V4_Drainage.pdf Markup Summary

DESIGNED BY	JRH	SCALE	DATE	08-28-23
DRAWN BY	JRH	(H) 1" = 5'	SHEET	26 OF 29
CHECKED BY	(V) 1" = N/A	JOB NO.	1183.23

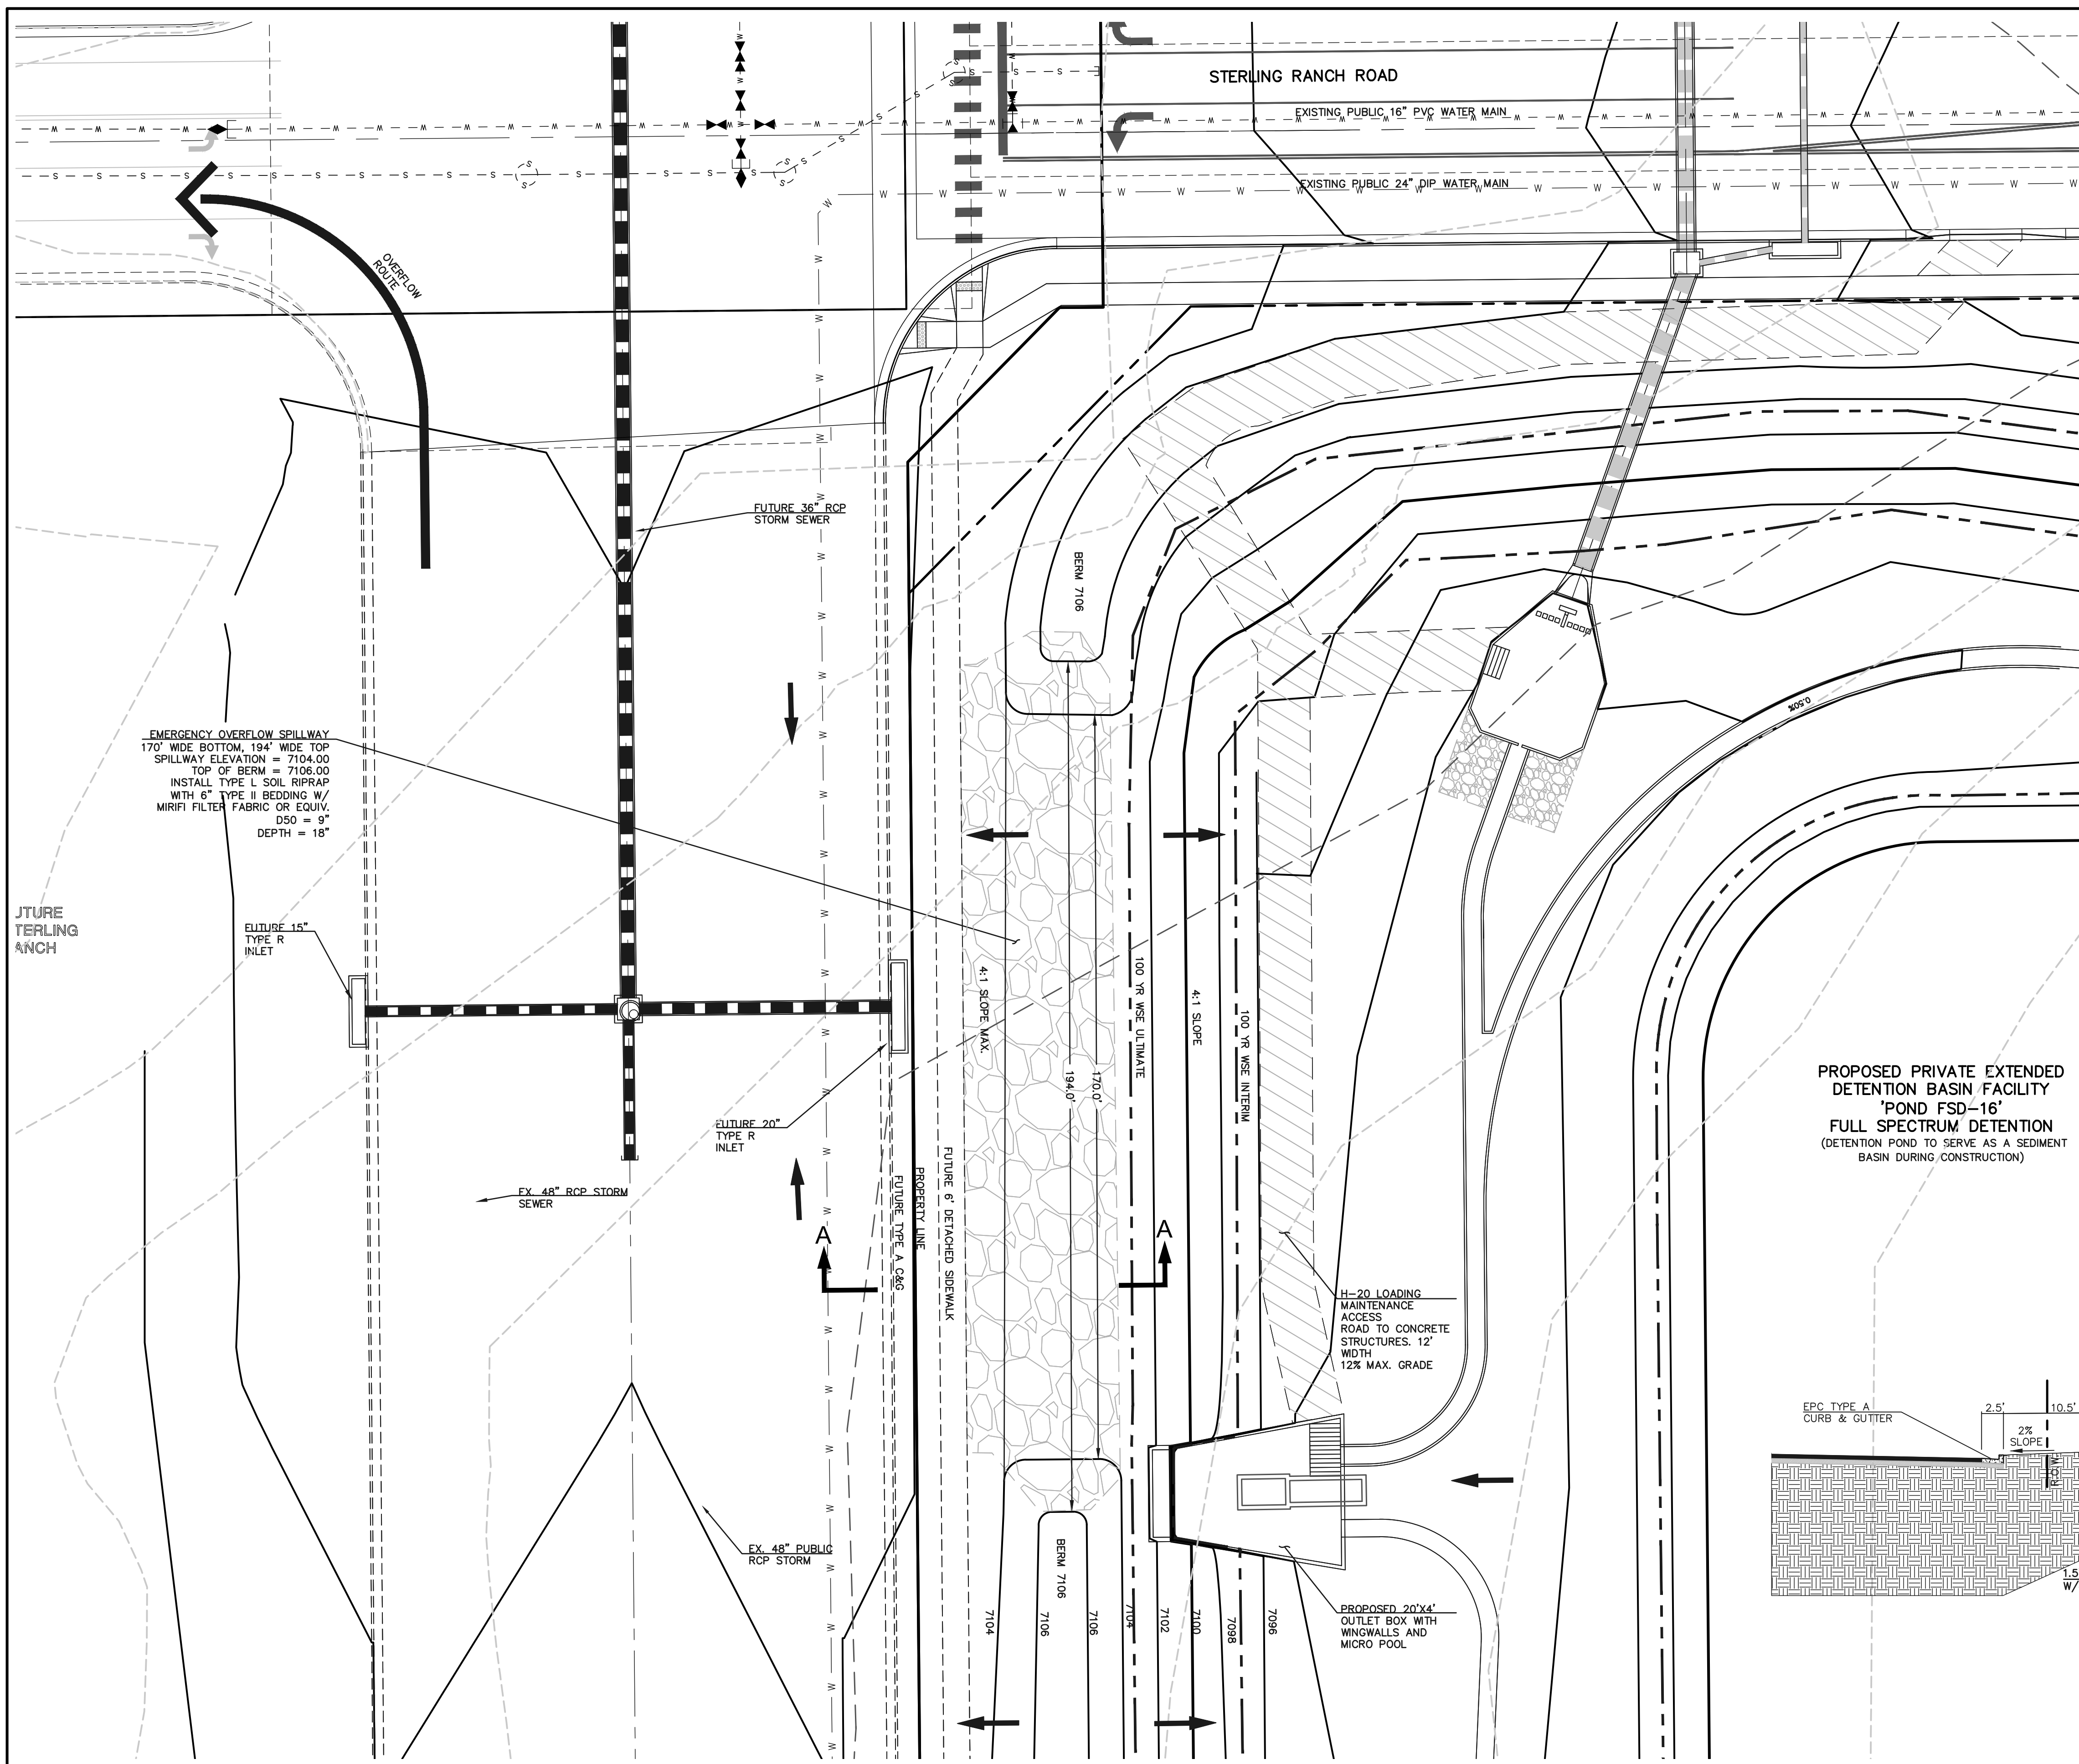
Pond detail sheet 27 in CDs shows 4:1 side slopes. Please reconcile between report and drawings to show same slope.

Now shown as 4:1 on CDs Sht 27 detail. Was 6:1 on detail with the last submittal

revised to 6:1

6:1 to be used
